Our Ref: CM/7/18/PL

**Town & Country Planning Act 1990 (as amended)
Town and Country Planning (Development Management Procedure) (England) Order 2015
Application for Planning Permission**

Development	Change of use of land from agricultural field to 60 No. tent pitches operating from April to October to include 2 No. plumbed screened portable showers, 2 No. plumbed portable toilets, 2 No. screened changing cubicles, 2 No. 2 screened portable chemical toilets with hand wash facilities & washing up/drying area within existing building.
Location	Woodpecker Camping Field Crookthorn Lane Climping

block plan 1:500@A2

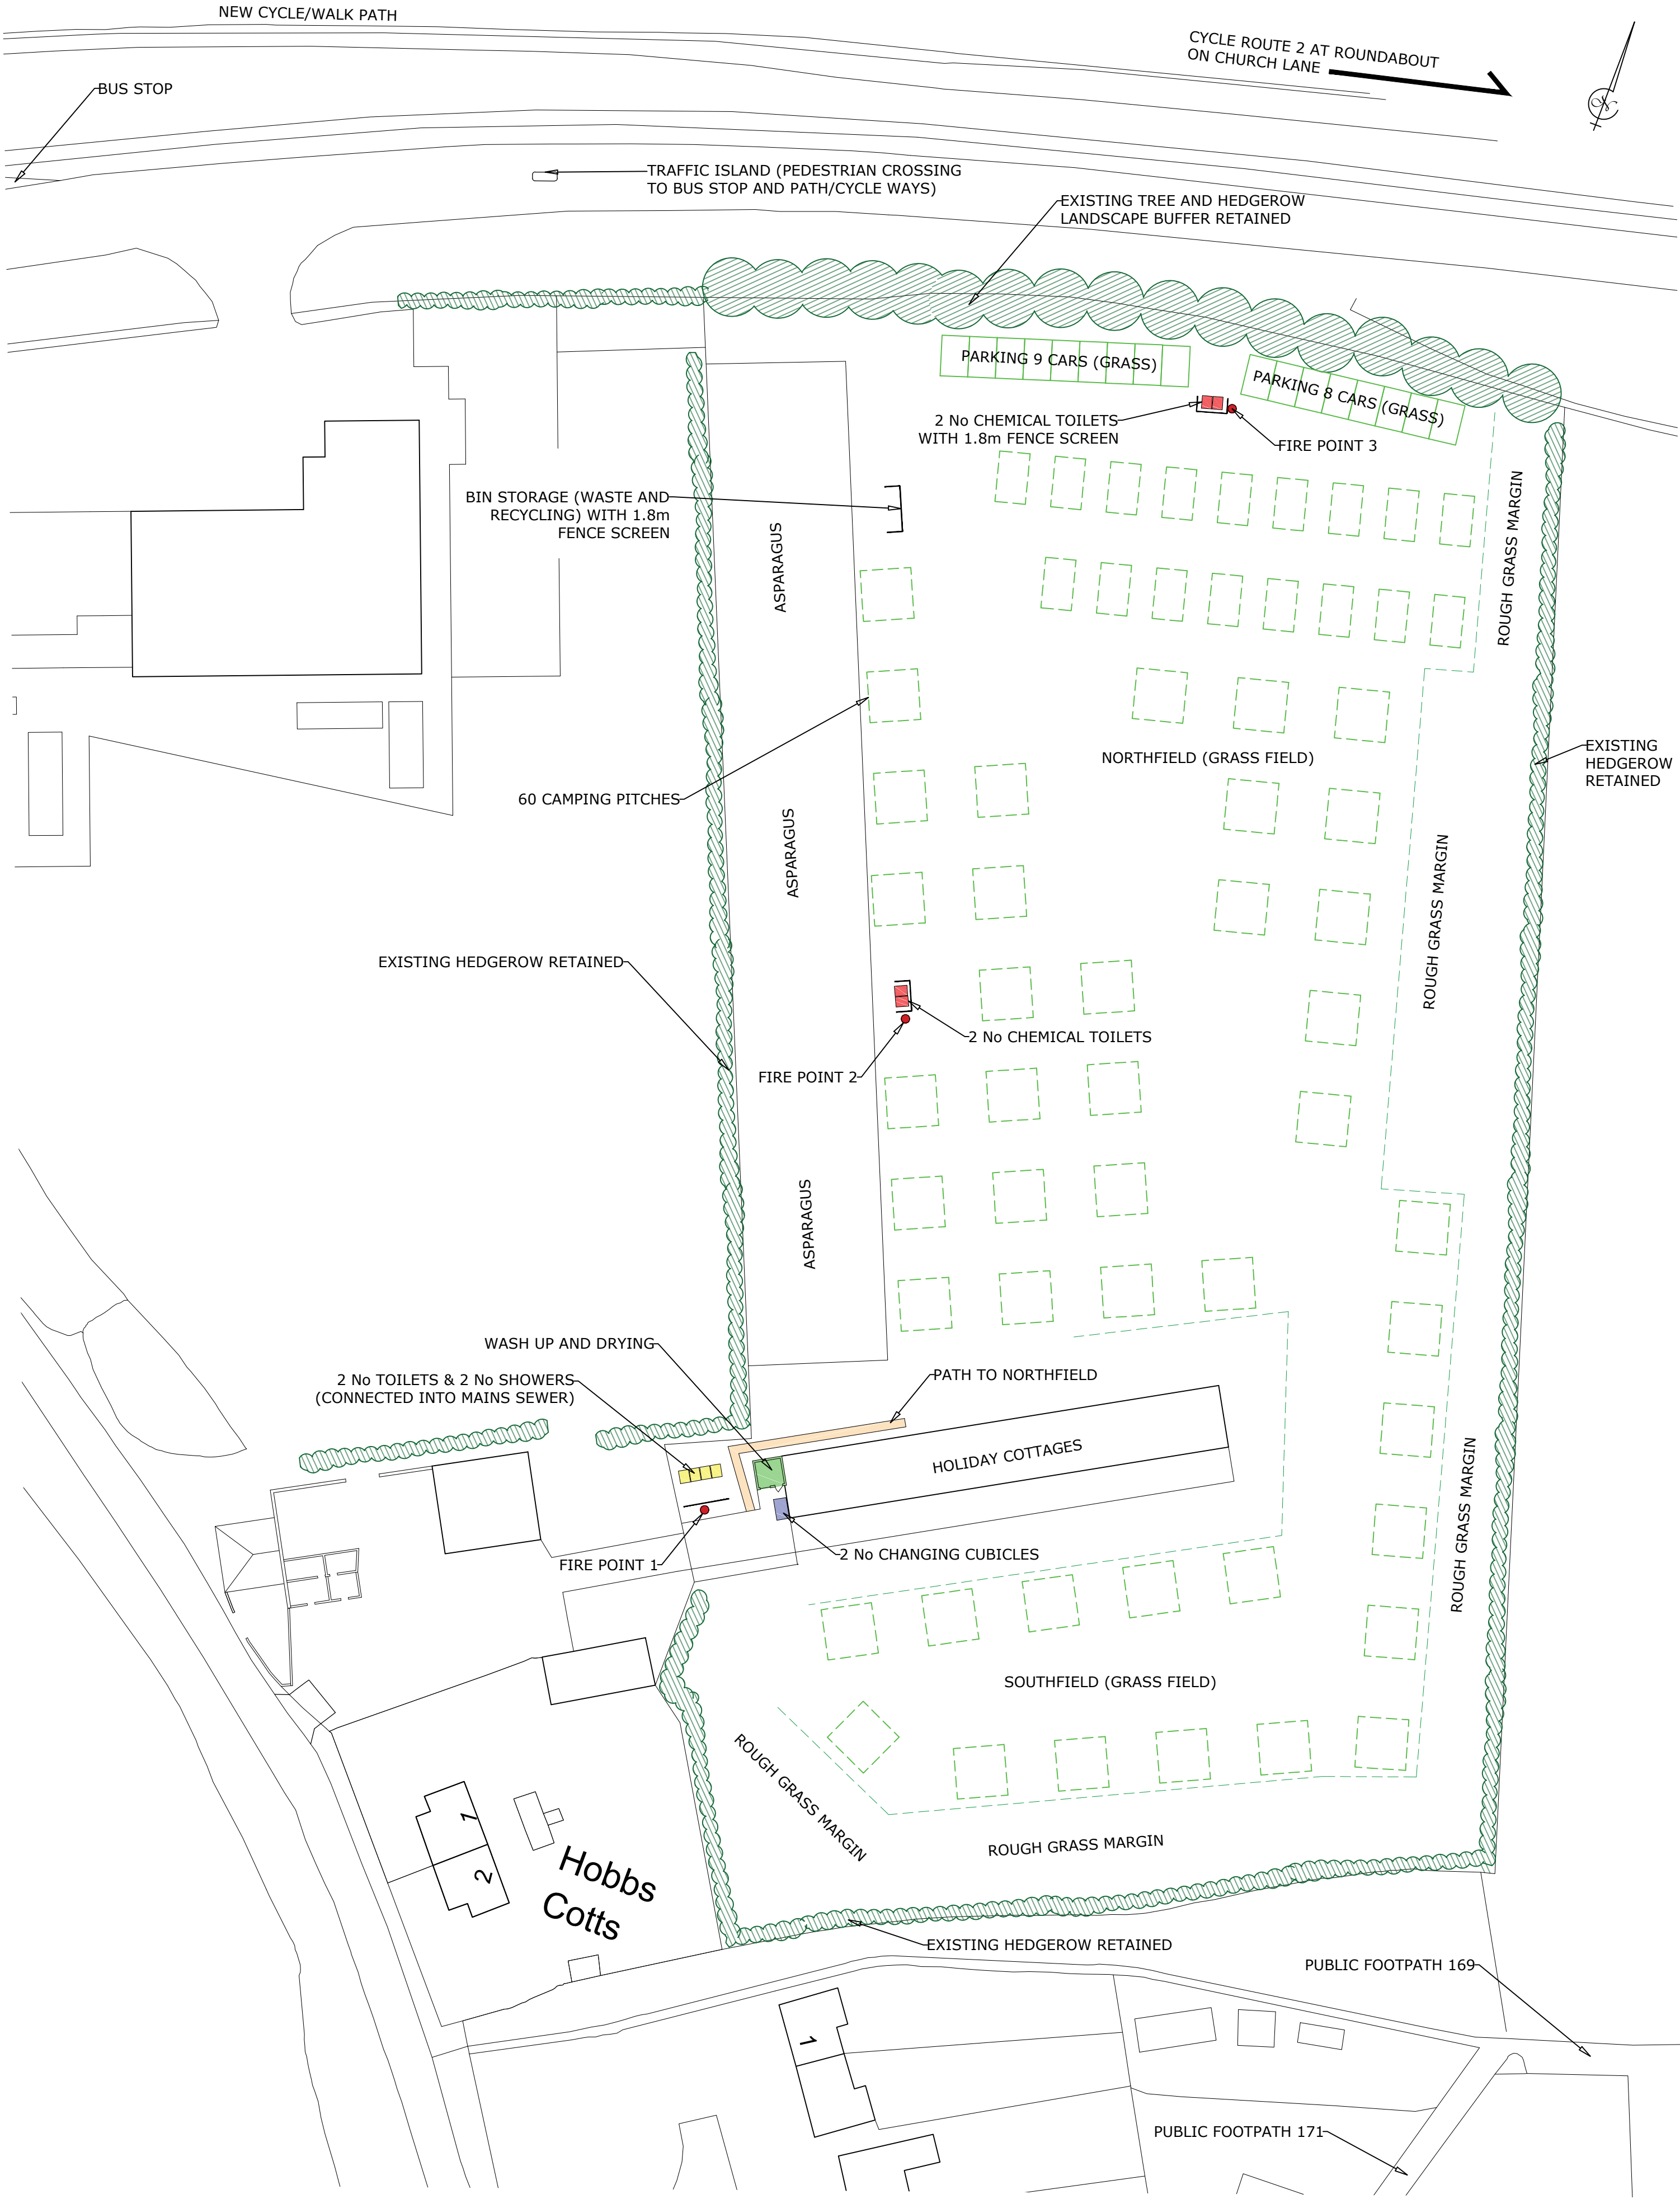
On the application form, 60 parking spaces has been indicated (question 10) whilst the block plan shows 17. Please either amend the application form or the block plan to coincide.

Please confirm if there is any significance between the dotted lines and the solid lines indicating the position of the pitches on the block plan.

fence screen
1:100@A3

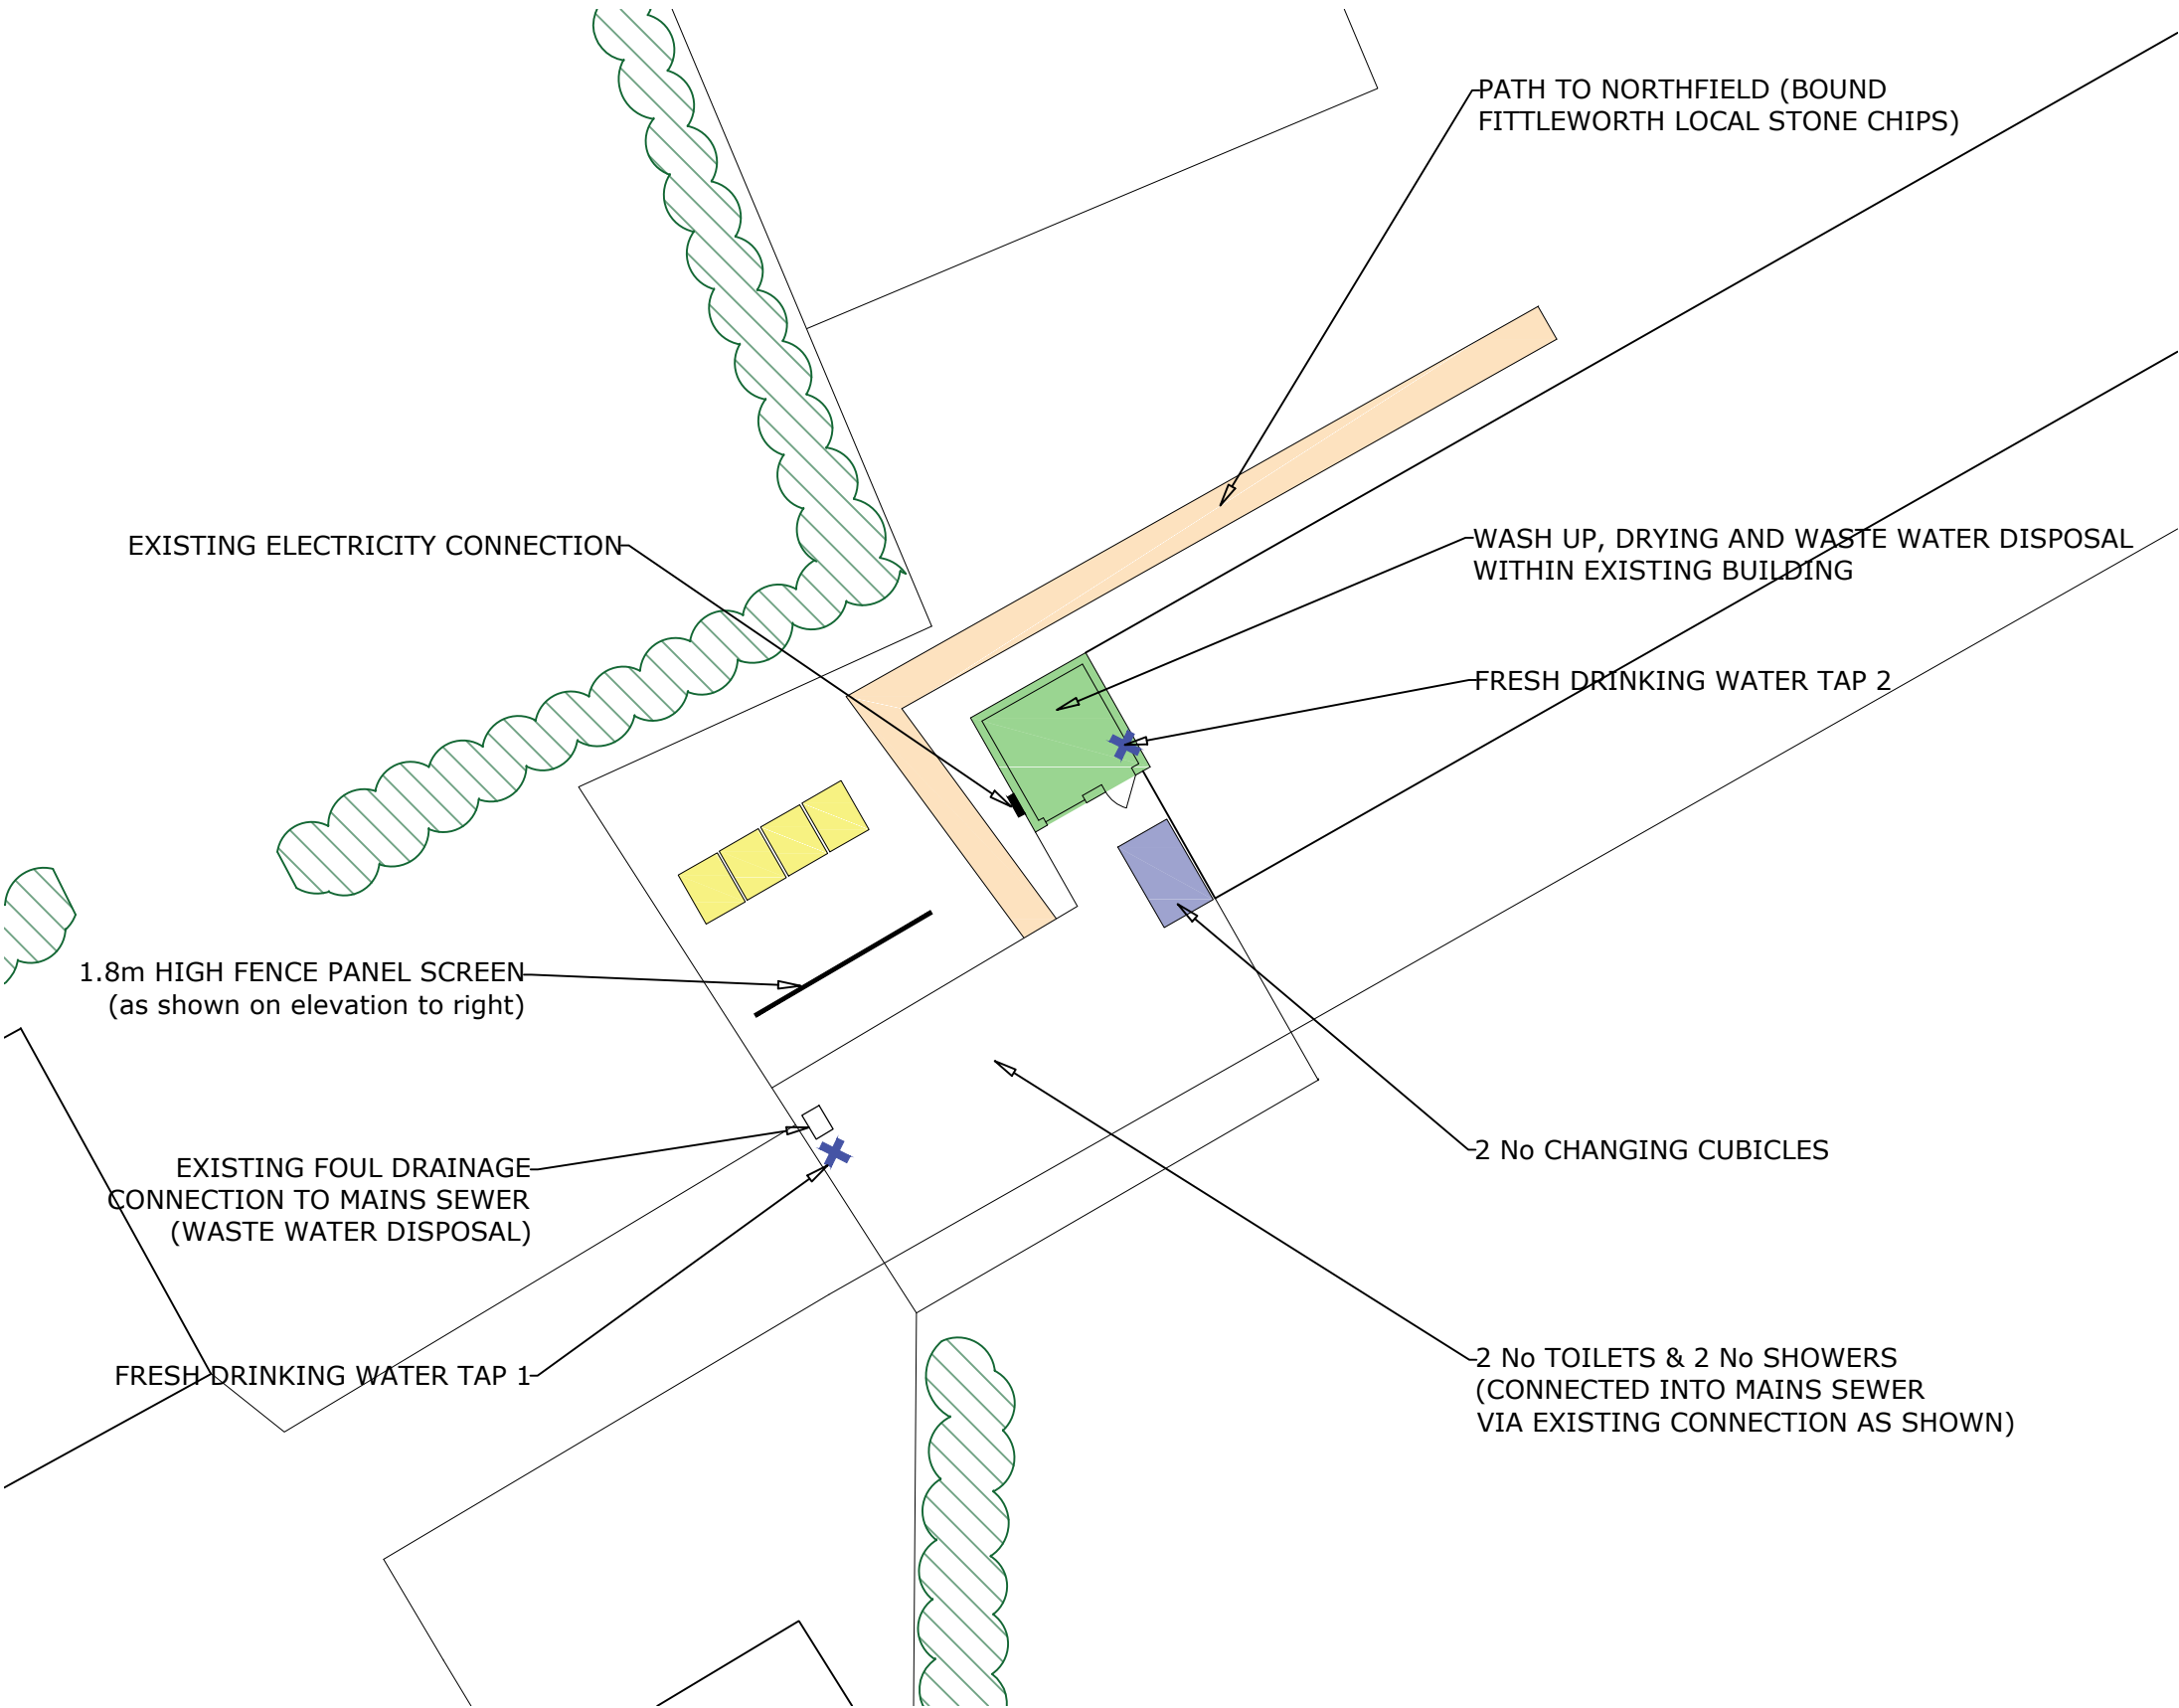
Please provide an elevation of the proposed fence panel screen and provide the measurement in metres.
